PROJECT TITLE: Drainage Plan 1921 Richmond NE H-16 ZONE ATLAS/DRNG. FILE #: H16/D119
 DRB #: 95-298 EPC #: _____ WORK ORDER #: _____
 LEGAL DESCRIPTION: Lot 4-B-1 in Block 1A, Miracerros Addition
 CITY ADDRESS: 1921 Richmond Drive NE
 ENGINEERING FIRM: DVC CONTACT: Debbie Cleft
 ADDRESS: 6212 Terrell NE PHONE: 2496196
Albuquerque, N.M. 87109
 OWNER: Bruce Caird CONTACT: Bruce Caird
 ADDRESS: 2425 San Pedro NE PHONE: 881-9696
 ARCHITECT: _____ CONTACT: _____
 ADDRESS: _____ PHONE: _____
 SURVEYOR: _____ CONTACT: _____
 ADDRESS: _____ PHONE: _____
 CONTRACTOR: _____ CONTACT: _____
 ADDRESS: _____ PHONE: _____

SUBJECT: Drainage violation at 1921 Richmond Dr. NE, Lot 4-B-1, Mirraceros Addition.

RE: *Engineer's Certification for 1921 Richmond Dr. NE (H16/D119) Engineer's Stamp Dated 6/21/98.*

TITLE: LOT 4-B-1  
DRAINAGE PLAN

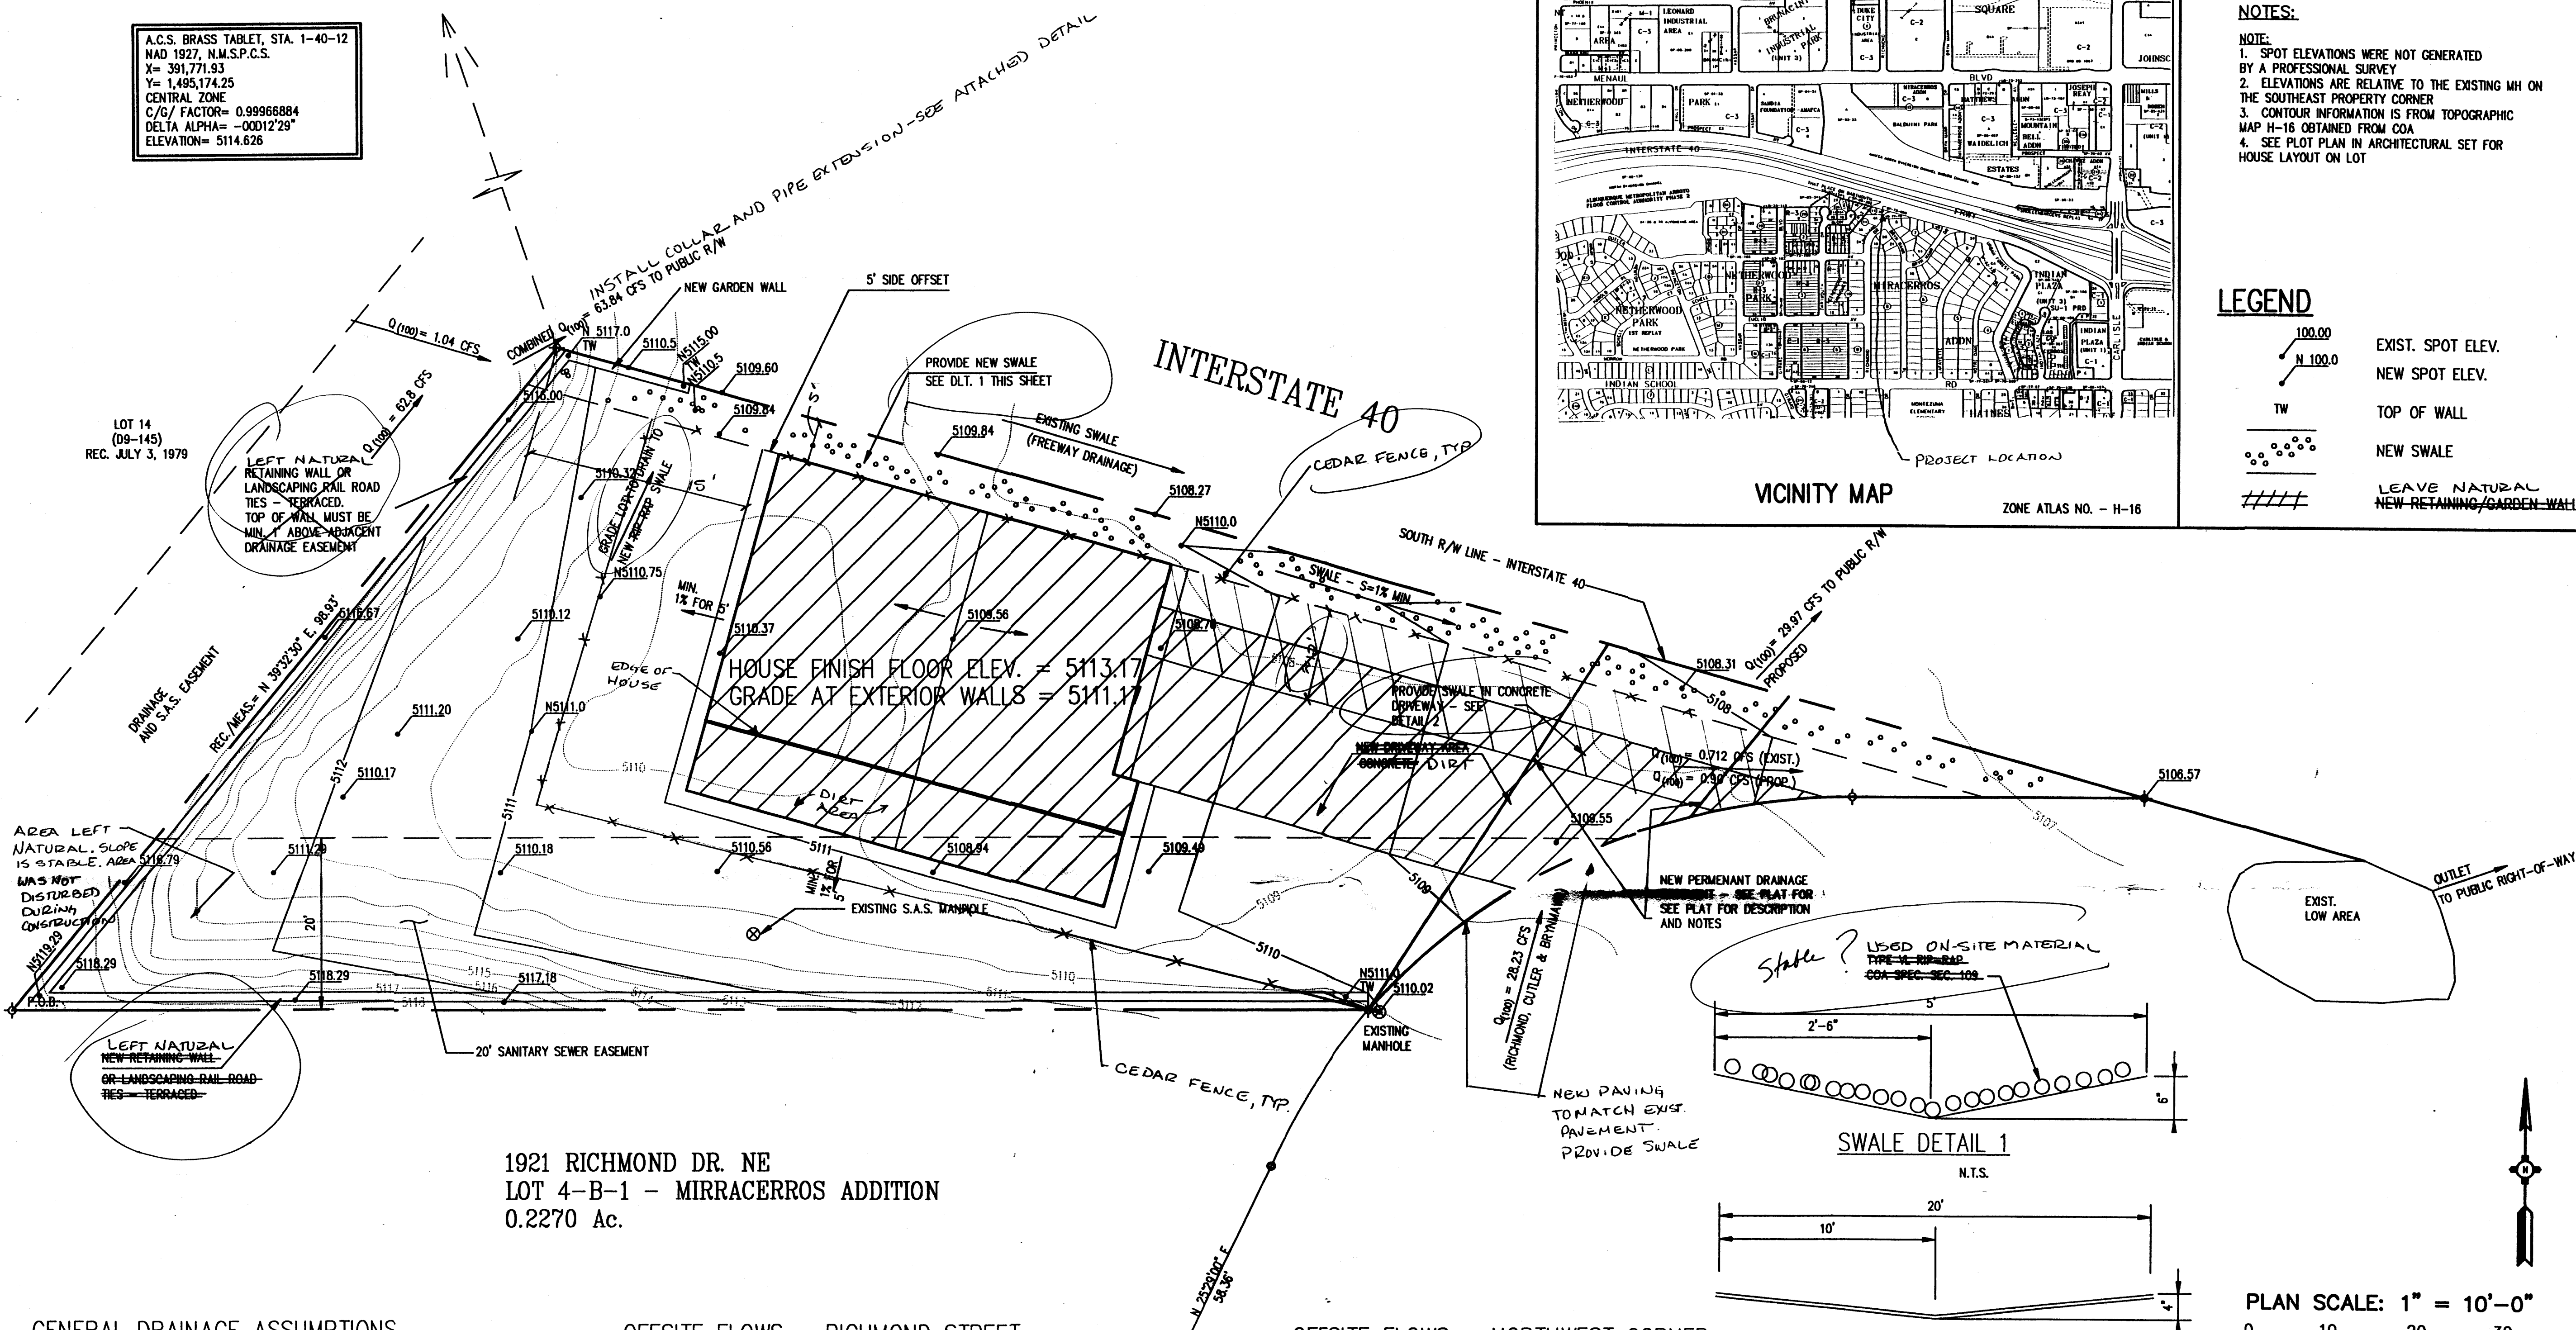
The approved Grading and Drainage plan showed several improvements which were not built. Until these issues are corrected, the certification plan cannot be accepted by City Hydrology. Please address the following comments:

1. The proposed concrete swale along the east property line, adjacent to the driveway, must be built to convey the 28.23 cfs from Richmond.
2. The retaining walls shown along the south and west property lines are required to prevent off-site flows from entering the site. These must be constructed. Was the garden wall in the northeast corner of the lot constructed?
3. The rip-rap swale along the north property line was not built according to the plan. Provide information to demonstrate that the "on-site material" used is comparable to the required rip-rap.
4. It appears from the certification plan that the house was shifted to the north. The plan is unclear on the location of the existing driveway.
5. It appears that the culvert issue has been resolved with the Highway Department. Please certify that the culvert end modifications have been done in accordance with the NMSHTD details.

1. The swale will be constructed in conjunction with the construction of the NMSHTD culvert into the right-of-way.
2. Because of the configuration of the lots in the vicinity, there is not any offsite flows. The grading and drainage plans show the source of all of the off-site and on-site flows. The retaining walls were originally shown to be constructed of either concrete or terraced railroad ties. They were shown to maximize the yard space for the owner, not for drainage control. You will note that the property owner chose to fence a much smaller space for a yard which made the walls unnecessary. The sloped area is stable and does not need retaining walls.

3. The on-site material is decomposed granite and sand. It does not compare to rip-rap. The swale was designed to take the overflow from the culvert above since it was improperly constructed. Now that the culvert is going to be diverted directly into the NMSHTD right-of-way, no swale is necessary.

4. The house constructed was smaller than the proposed pad envelope. The northern setback remains the same as shown on the plans. The driveway align with the 5' setback.

TITLE: LOT 4-B-1  
DRAINAGE PLAN

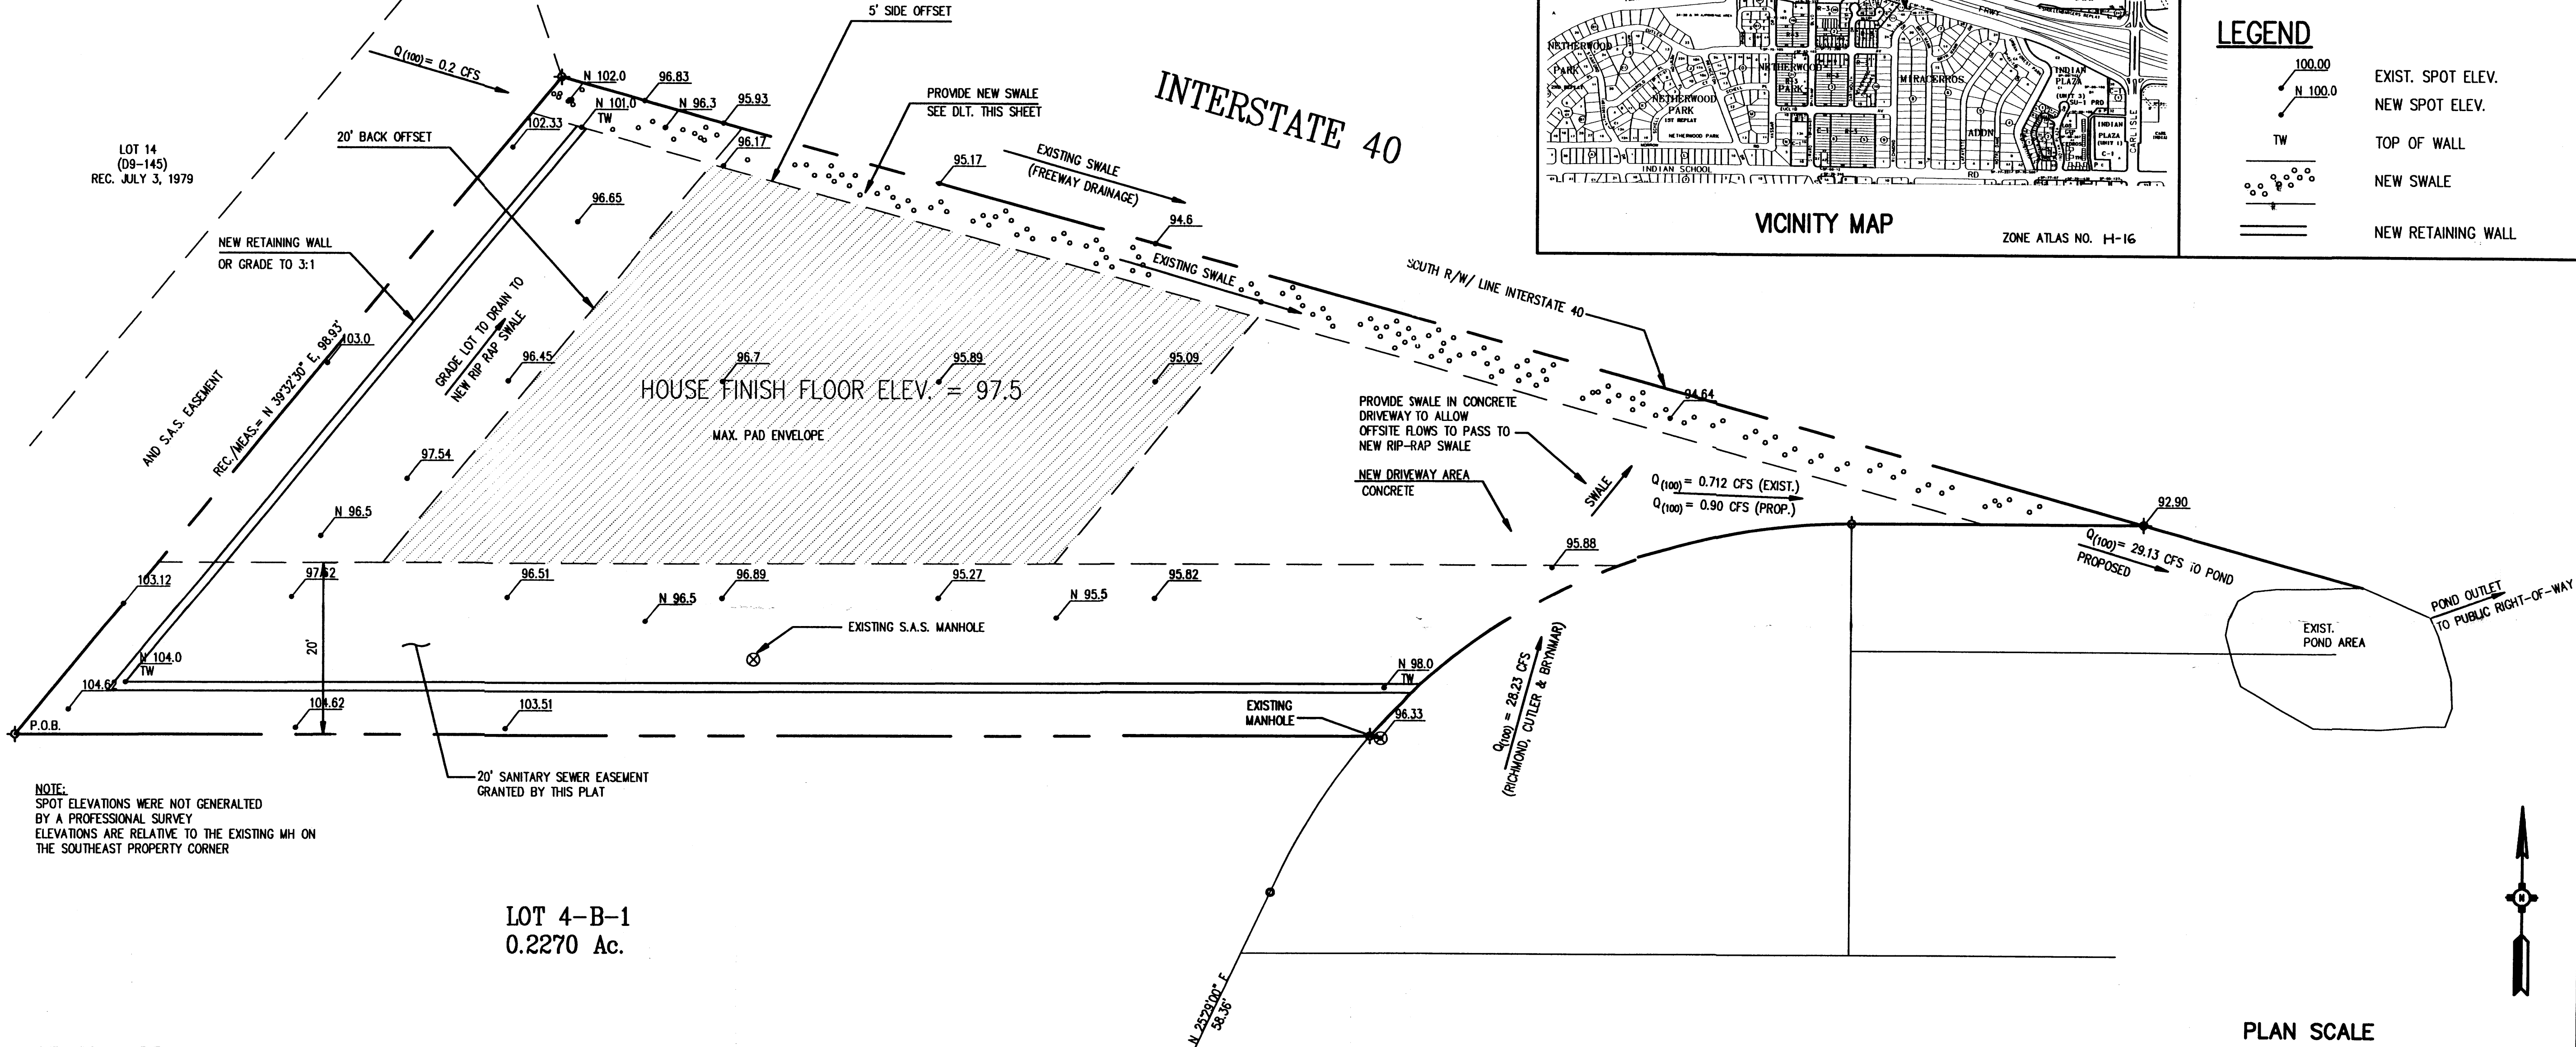
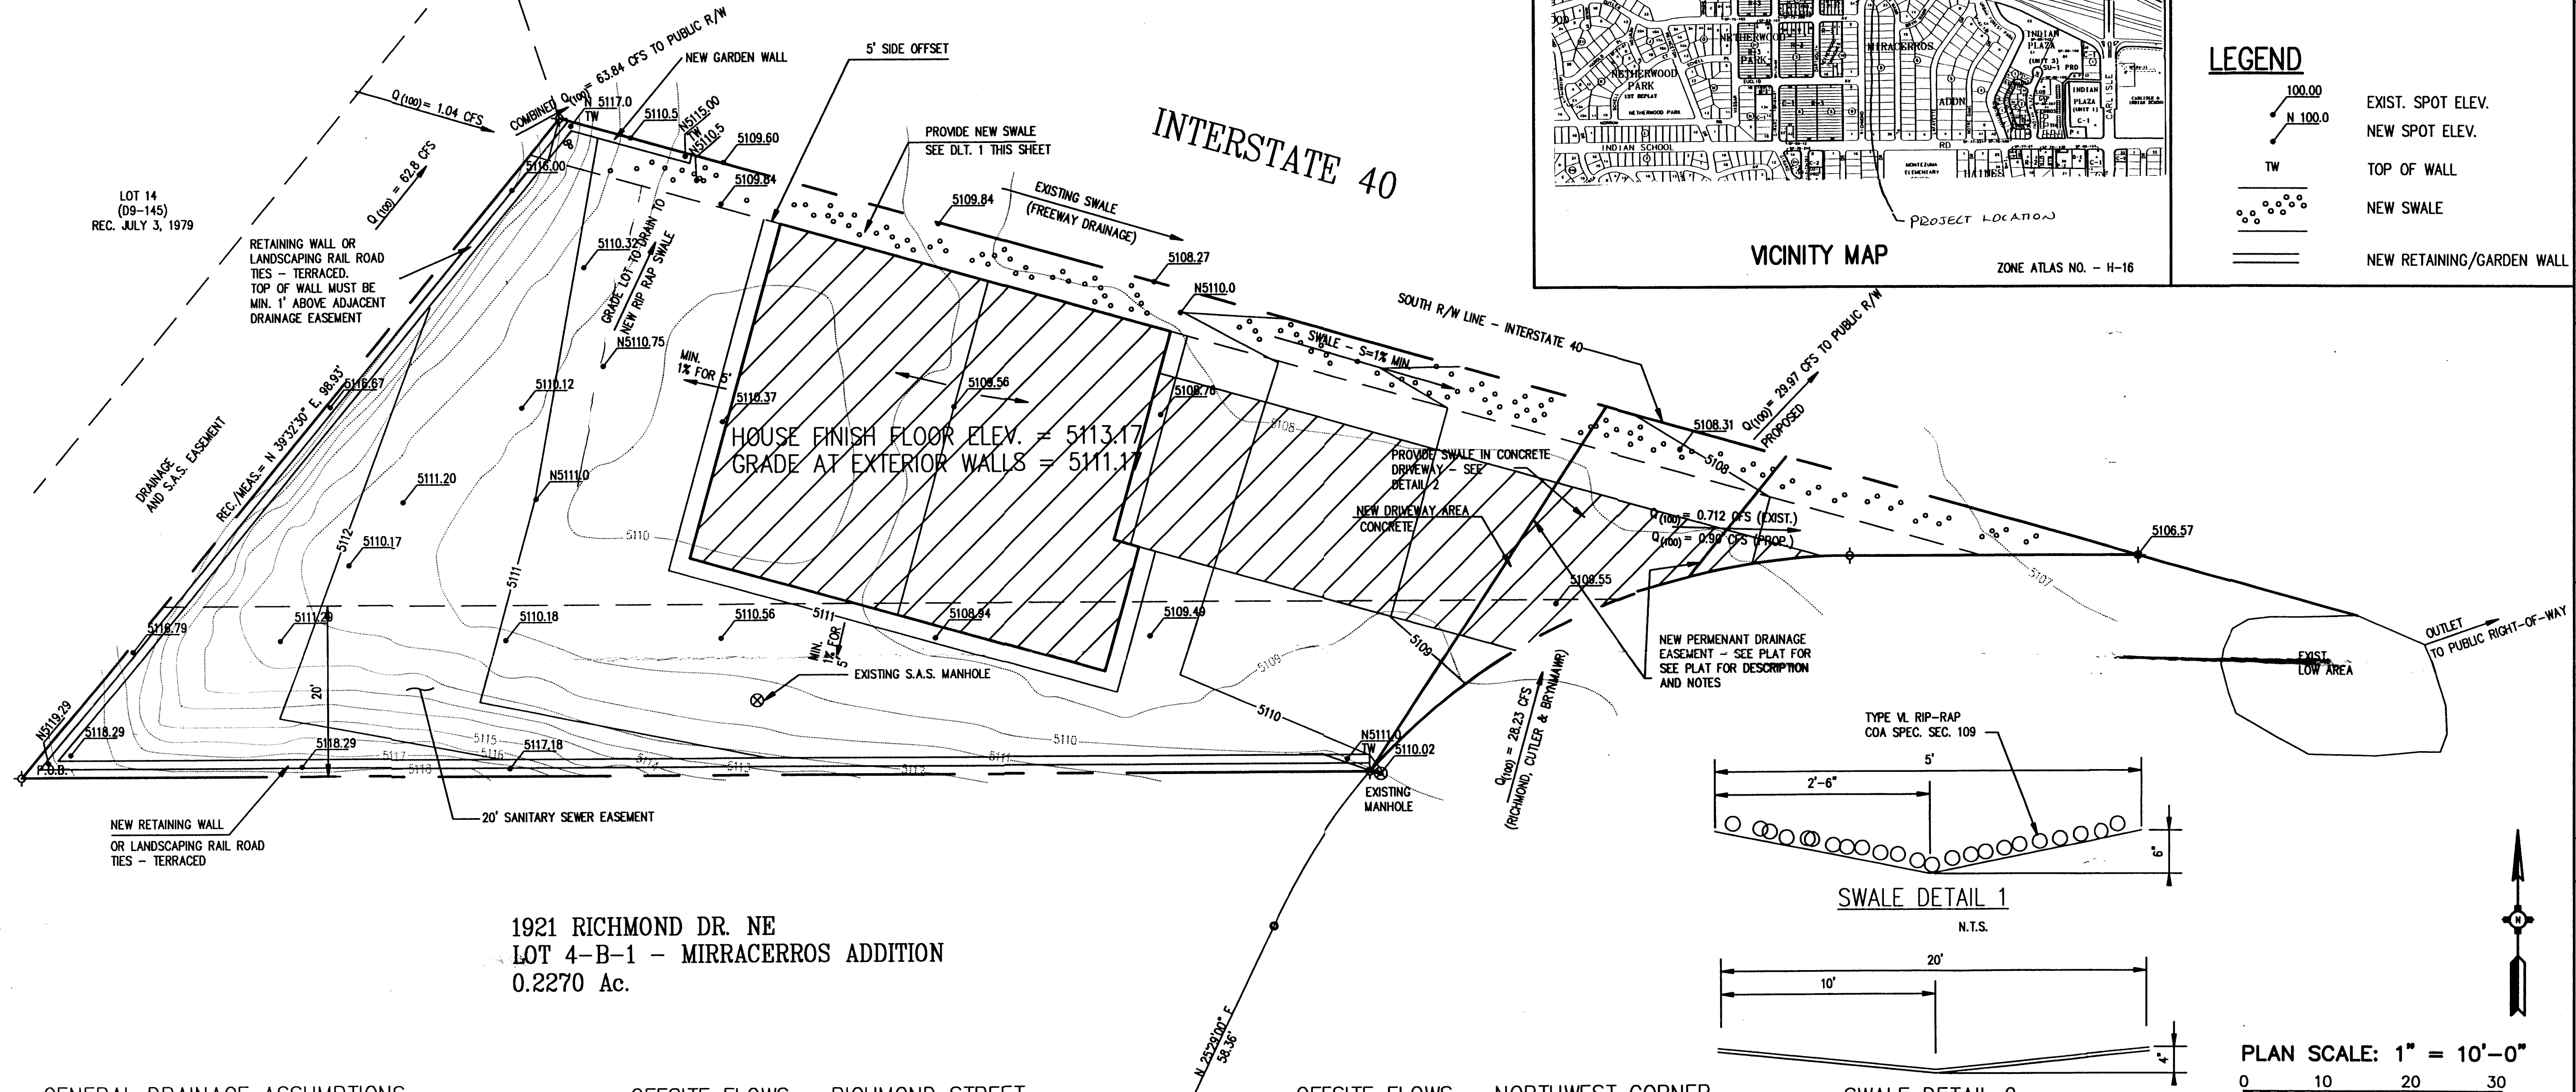
1. Please show finish floor elevation to mean sea level. All other elevations must be referenced to mean sea level.
2. Show proposed floor plan.
3. Whose property is the existing pond on? Is it public drainage easement?
4. Provide pond capacity calculations and show elevations.
5. Show existing and proposed contours.
6. The note that reads "20' Sanitary Sewer Easement granted by this plat," is confusing. An existing SAS line is contained within this boundary, therefore the easement is most likely existing.
7. Is the existing swale contained within a drainage easement? Do not take public waters onto private land.
